Re: Carlisle and Menaul - Sketch Plat Submittal

12. [PR-2024-009947](#)

[PS-2024-00123](#) – SKETCH PLAT

DRB Project Number: 2024-009947
3535 Menaul-American Square

SITE PLAN AND CROSS SECTION  
EXHIBIT

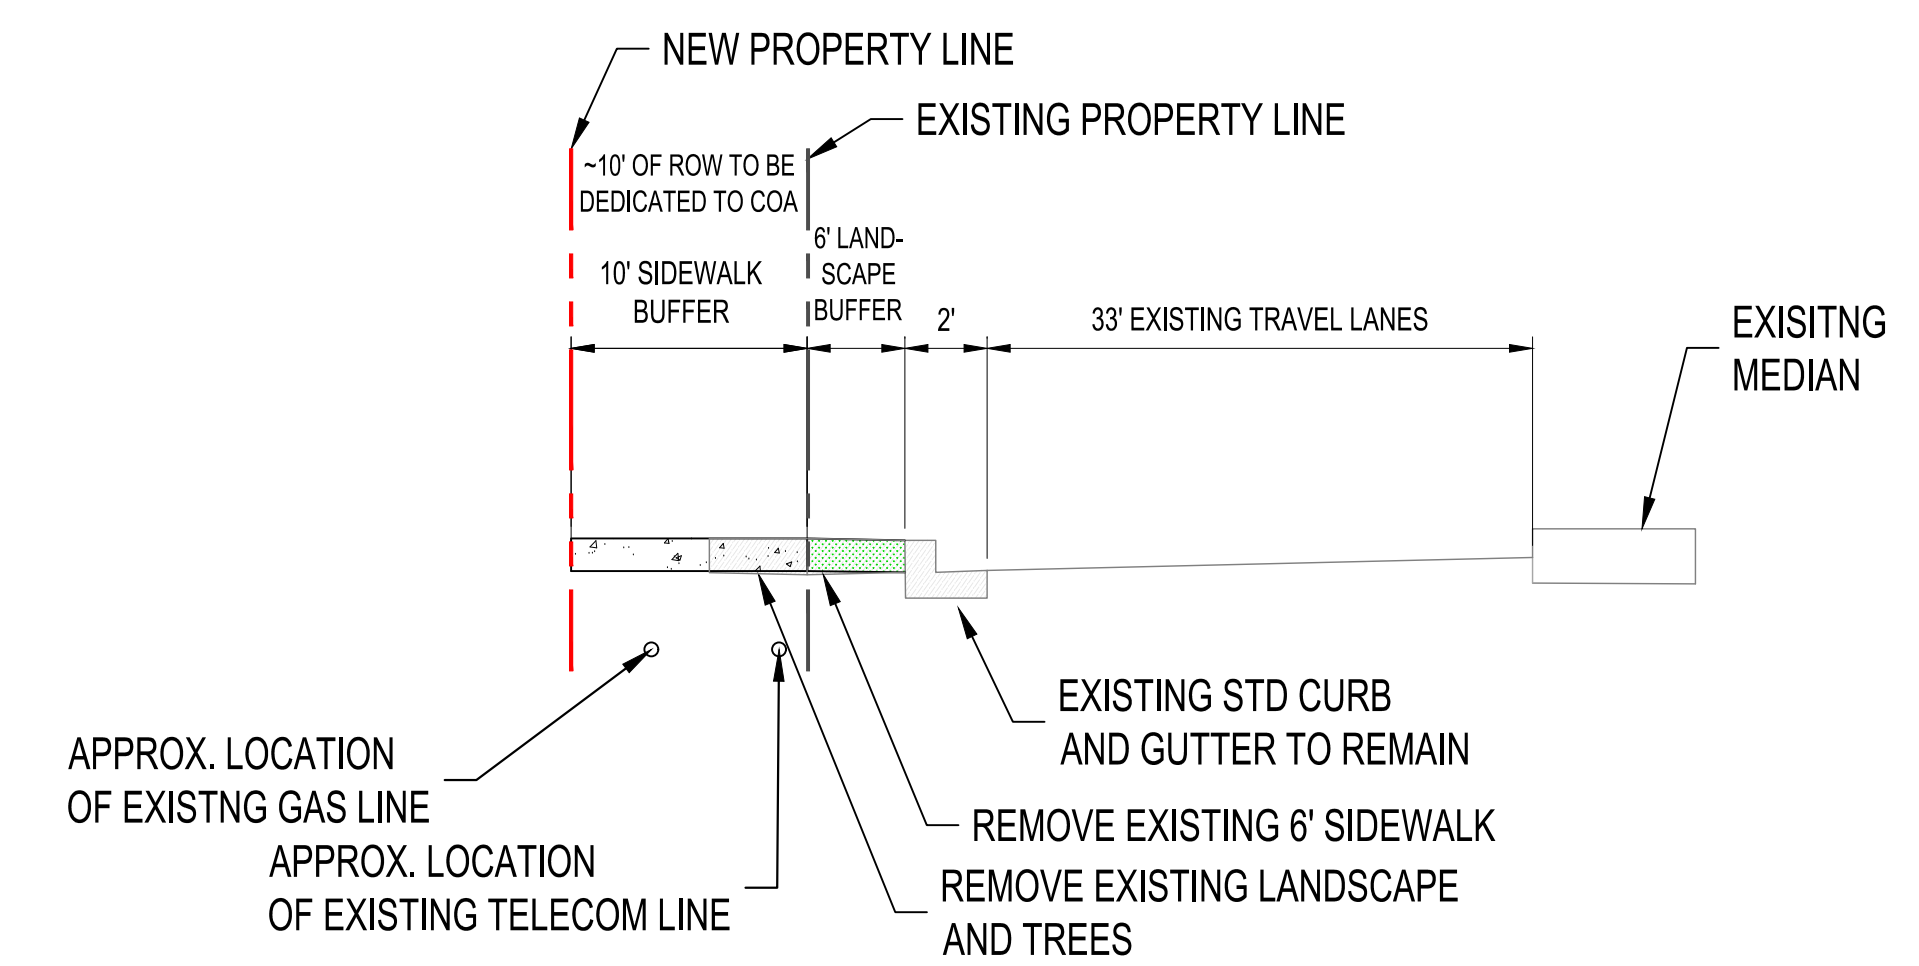
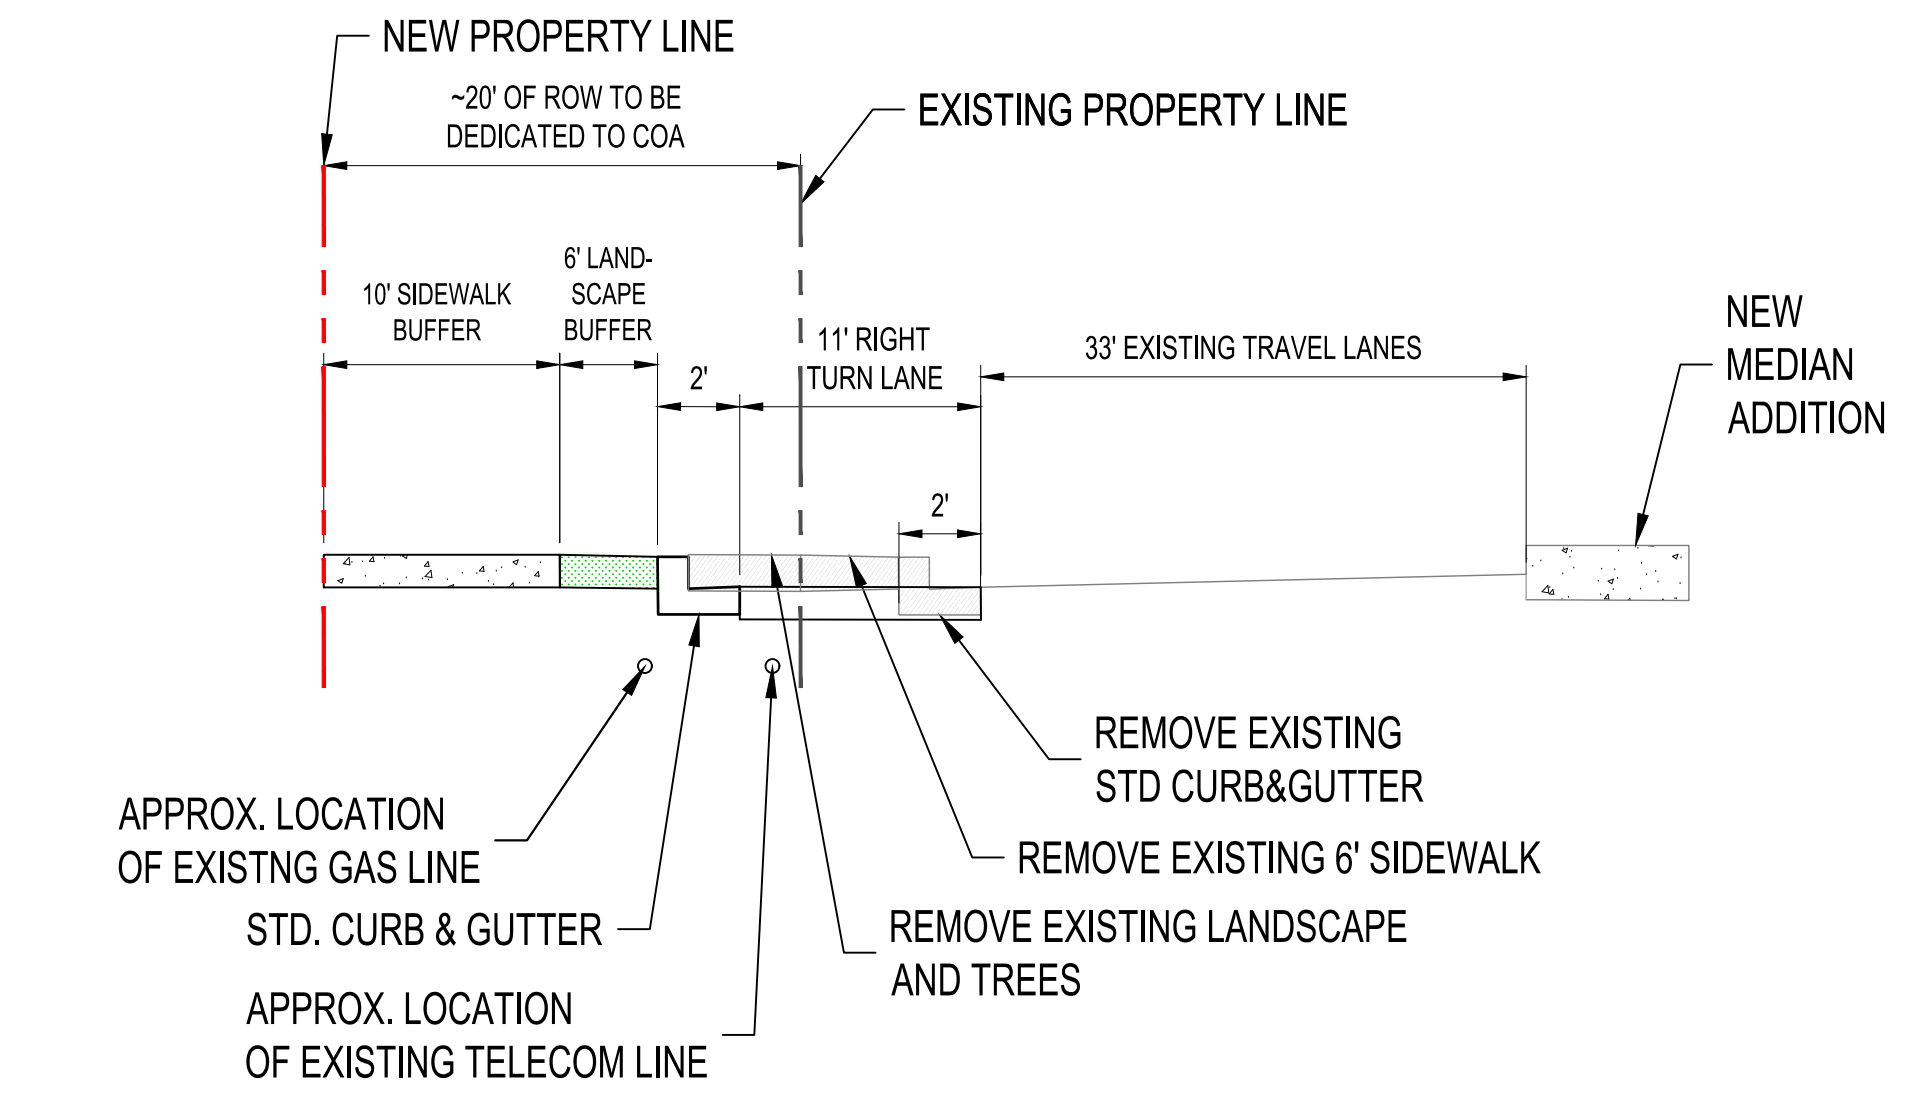
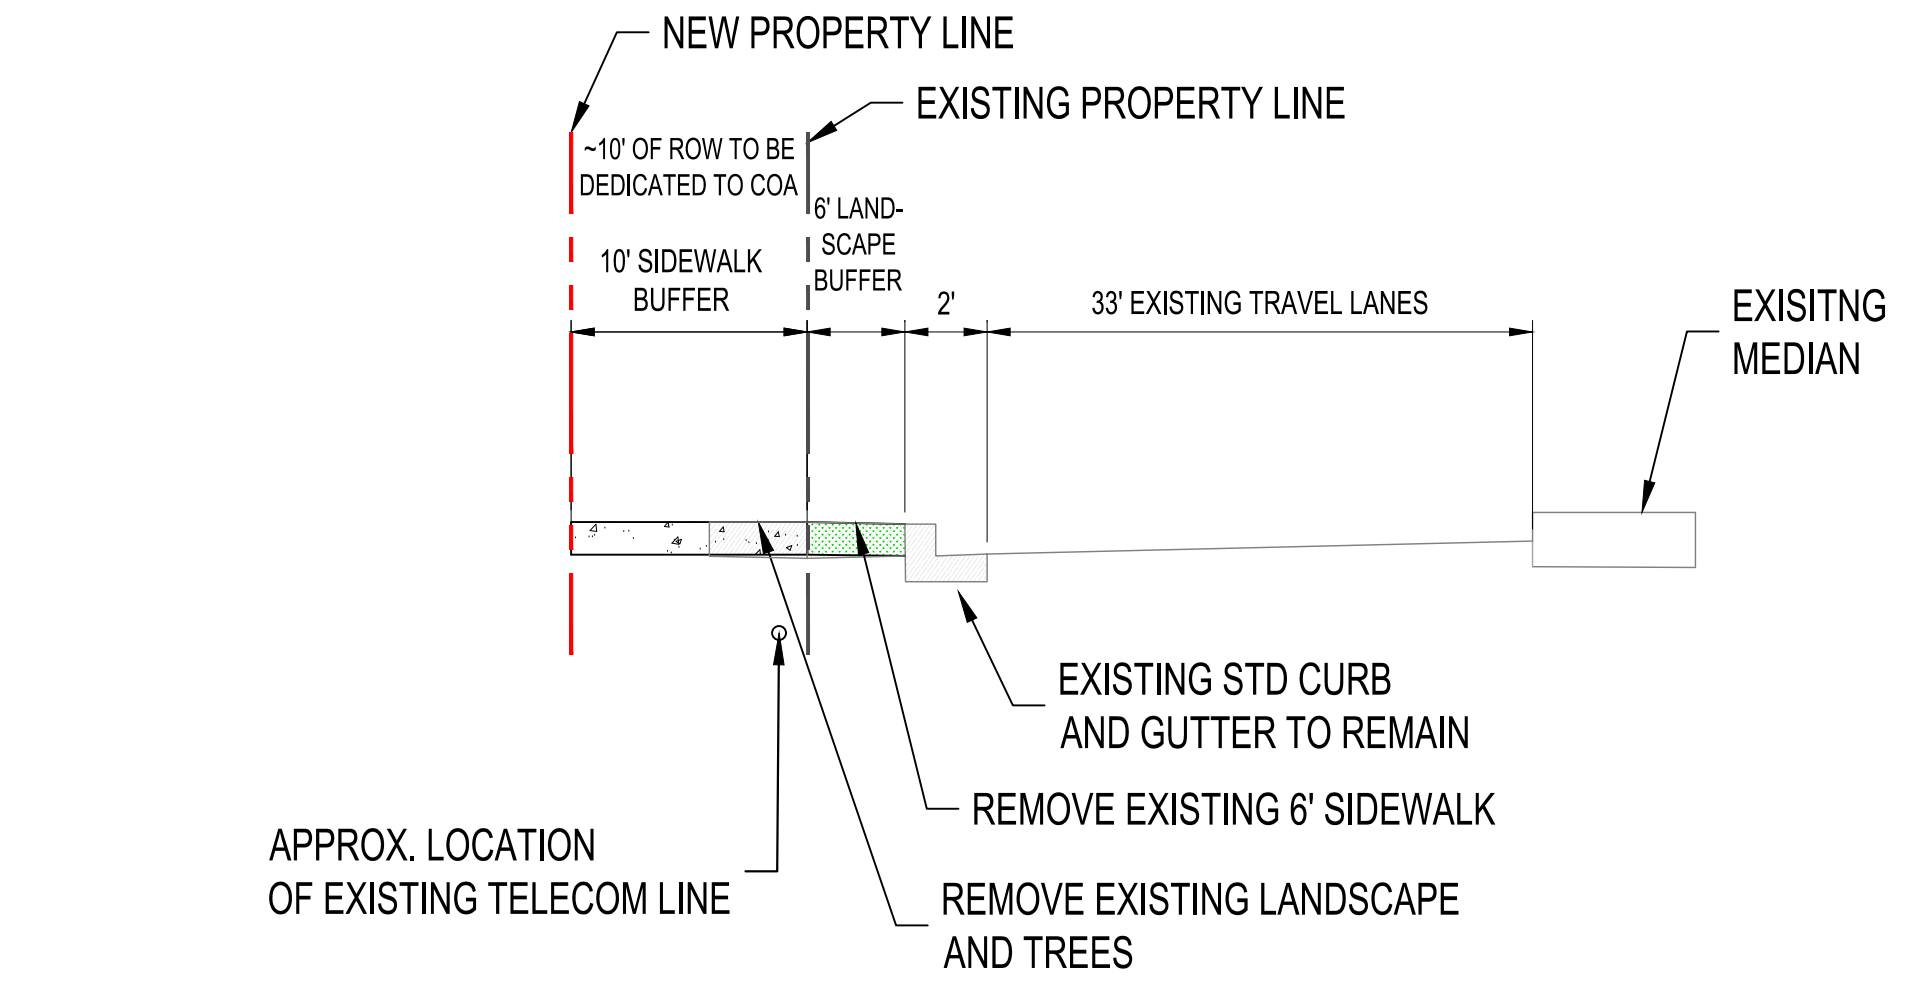
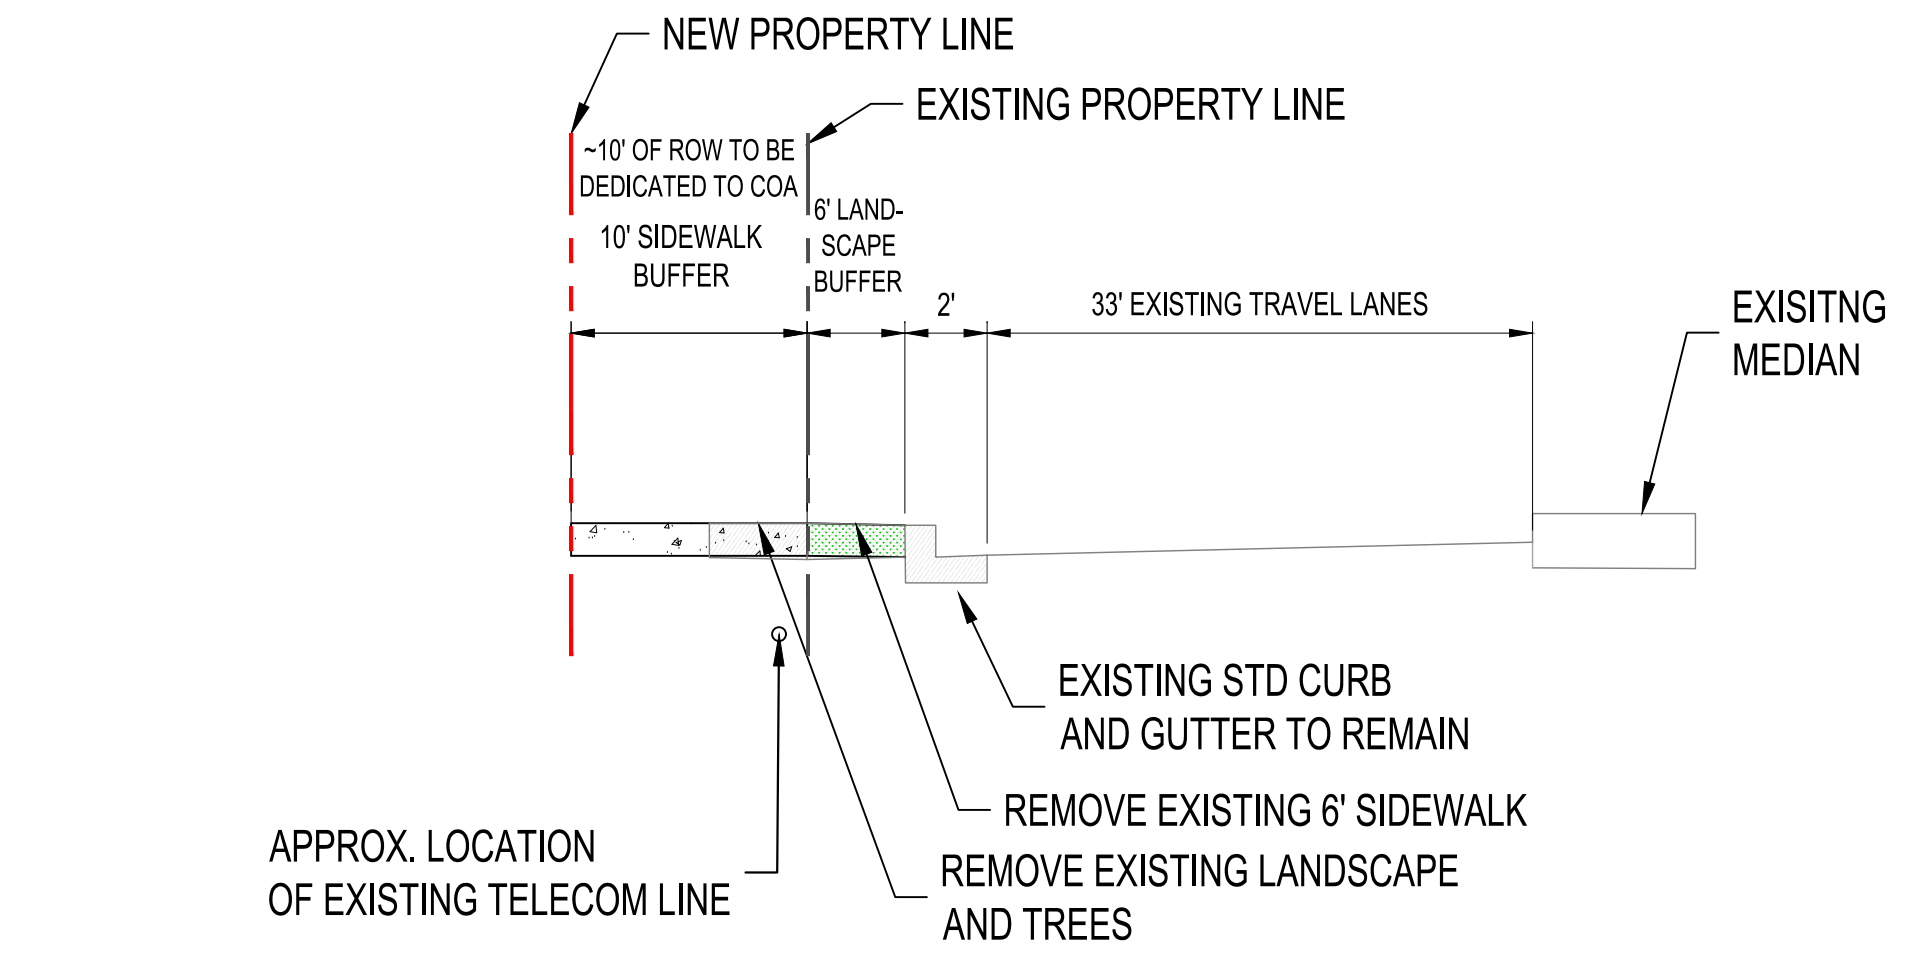
1. Menaul is a Principal Arterial and Carlisle is a Minor Arterial both in a center and both require 10' sidewalk with a 6' to 8' landscape buffer. Please provide a diagram dimensioning existing sidewalks and buffer to determine if these need to be widened.
2. All internal roads should be placed within access easements.
3. For future development an approved TCL will be required prior to site plan. Please fill out and submit a Traffic Scoping Form to Curtis Cherne (ccherne@cabq.gov) to determine if a traffic study will be required.
